Application by Fosse Green Energy Park Limited for an Order Granting Development Consent for the Fosse Green Energy Park Project.

This letter sets out Lincolnshire County Council's (LCC) comments on the additional information and submissions received at Deadline 1, while noting the applicant's intention to provide further updated documents and information by Deadline 2 to respond to action points from Issue Specific Hearings (ISH) 1 and 2.

Figure 8-5

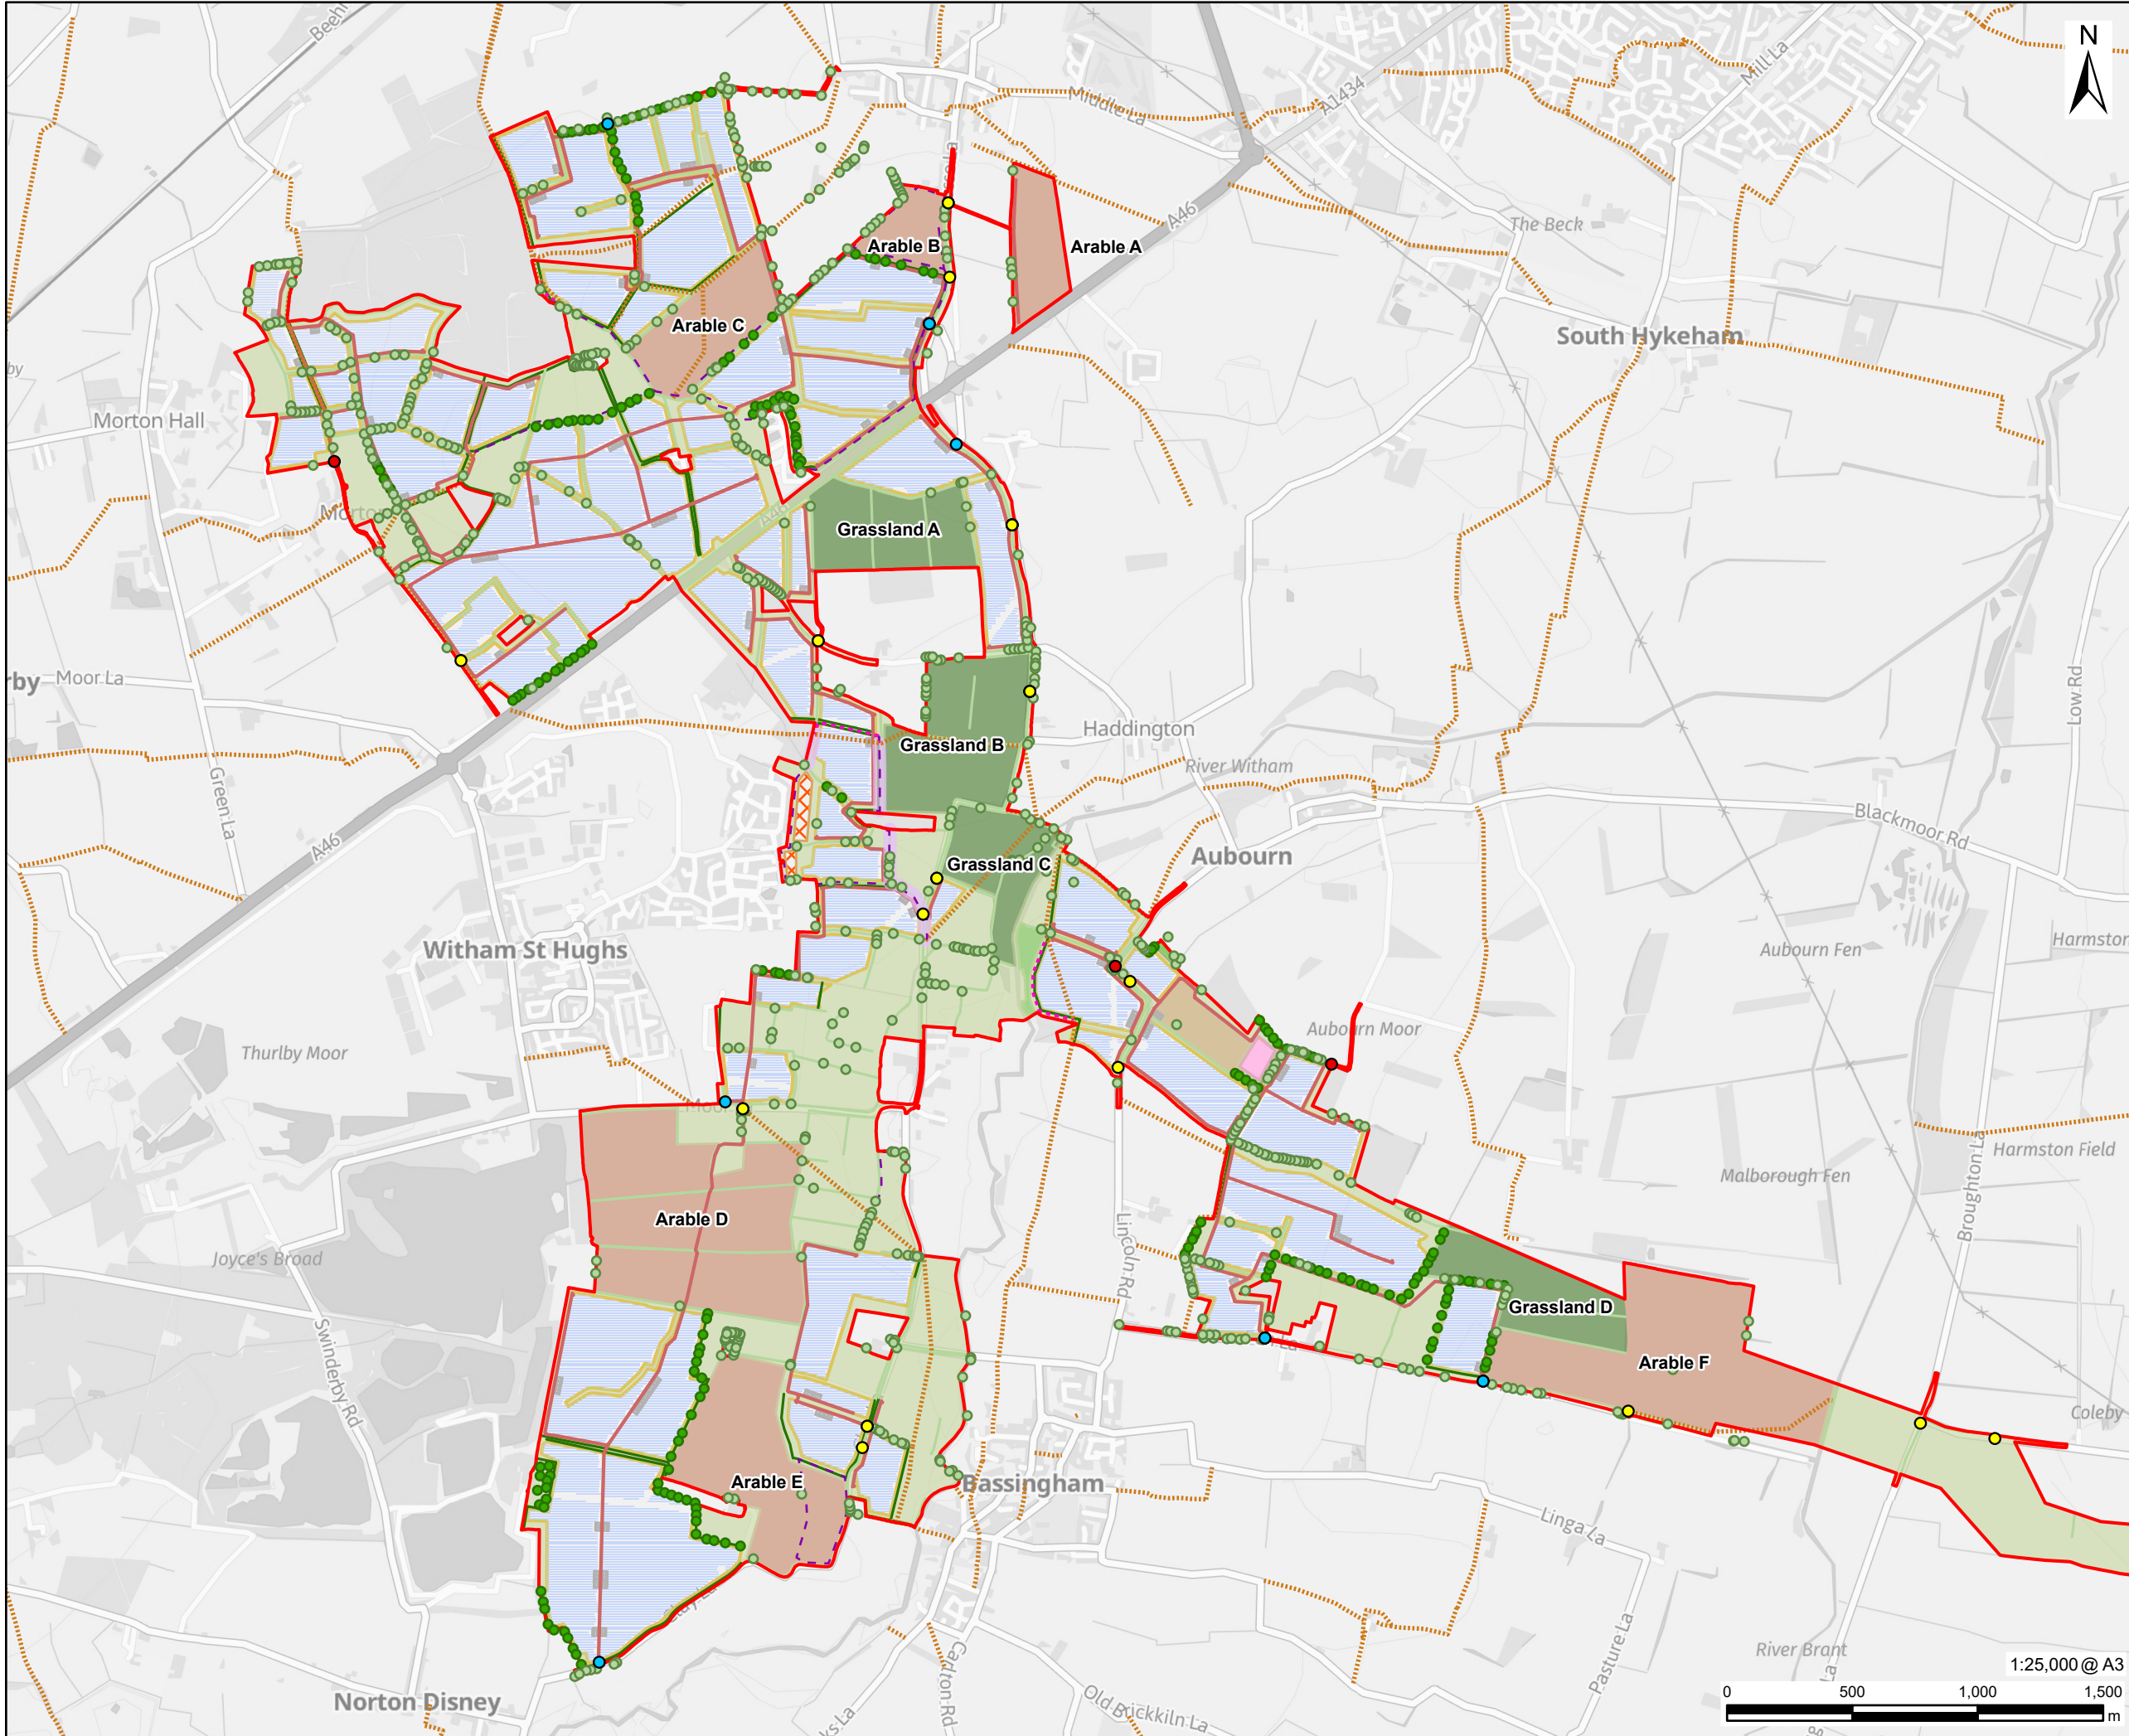
The **Landscape Environmental Management Plan (Rev 4) (REP1-039)**, for example, includes bird mitigation and habitat creation areas (section 1.3.2) however there is no detail on any ground preparation or whether there would be scrapes or other work which would go below the archaeological horizon. Some habitat creation requires ground preparation which would damage or destroy surviving archaeology particularly in land previously in agricultural use where surviving archaeology may be close to the current ground surface. These areas therefore need to be included in the evaluation work and the results can be used to inform the design process effectively.
